Our Ref: F/3/19/PL
Your Ref:

Town & Country Planning Act 1990 (as amended)
Town and Country Planning (Development Management Procedure) (England) Order 2015
Application for Planning Permission

Development Erection of farm shop/cafe.
Location H M Ford Open Prison Ford Road Ford

West Front Of building faces site

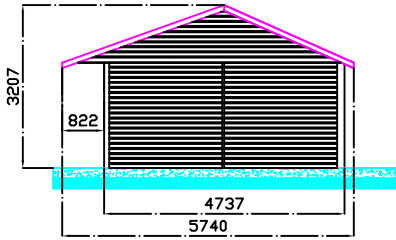
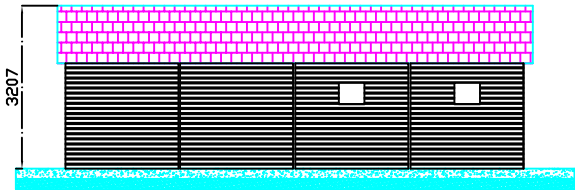
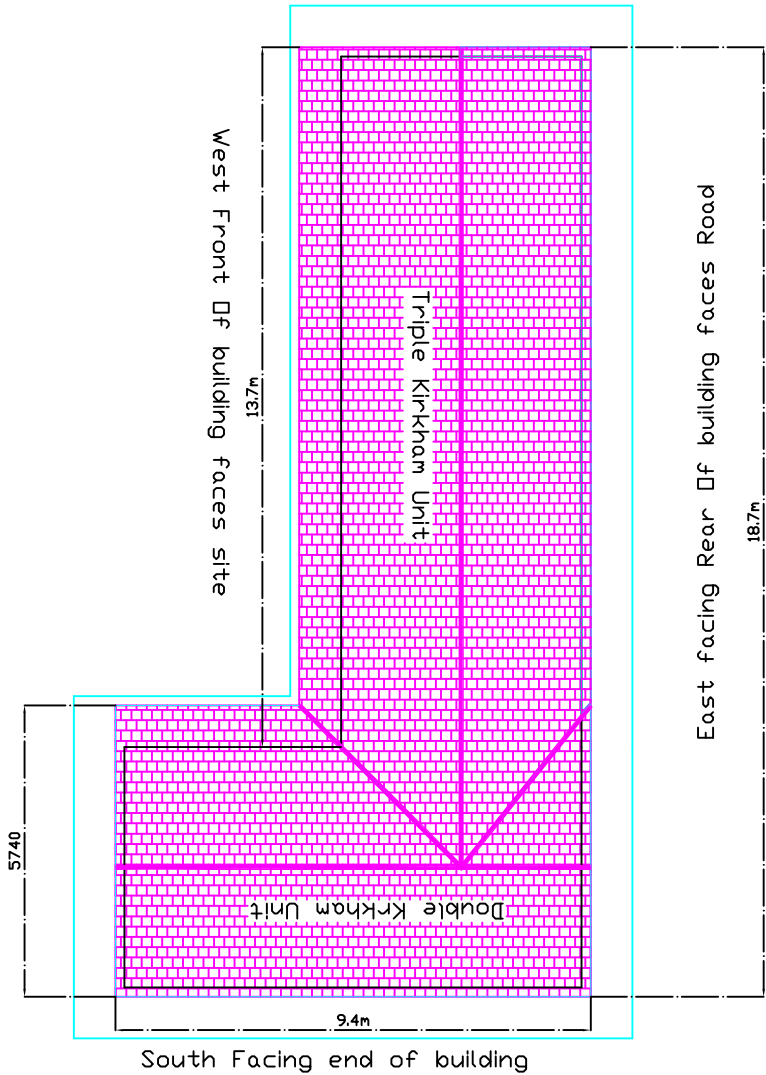
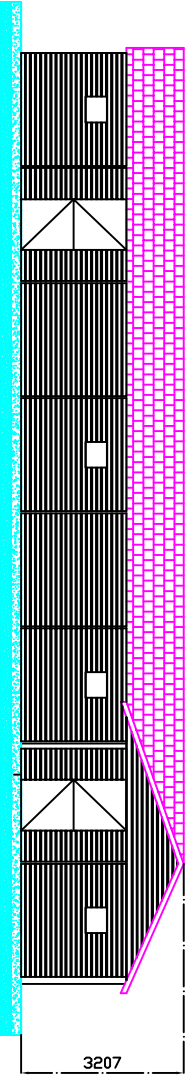
Please label all elevations as North, South, East or West as appropriate.

Please provide the fourth elevation, to scale.

The floor plan and elevations do not accord. Please amend accordingly.

Please provide measurements for the floor plan or provide a scale.
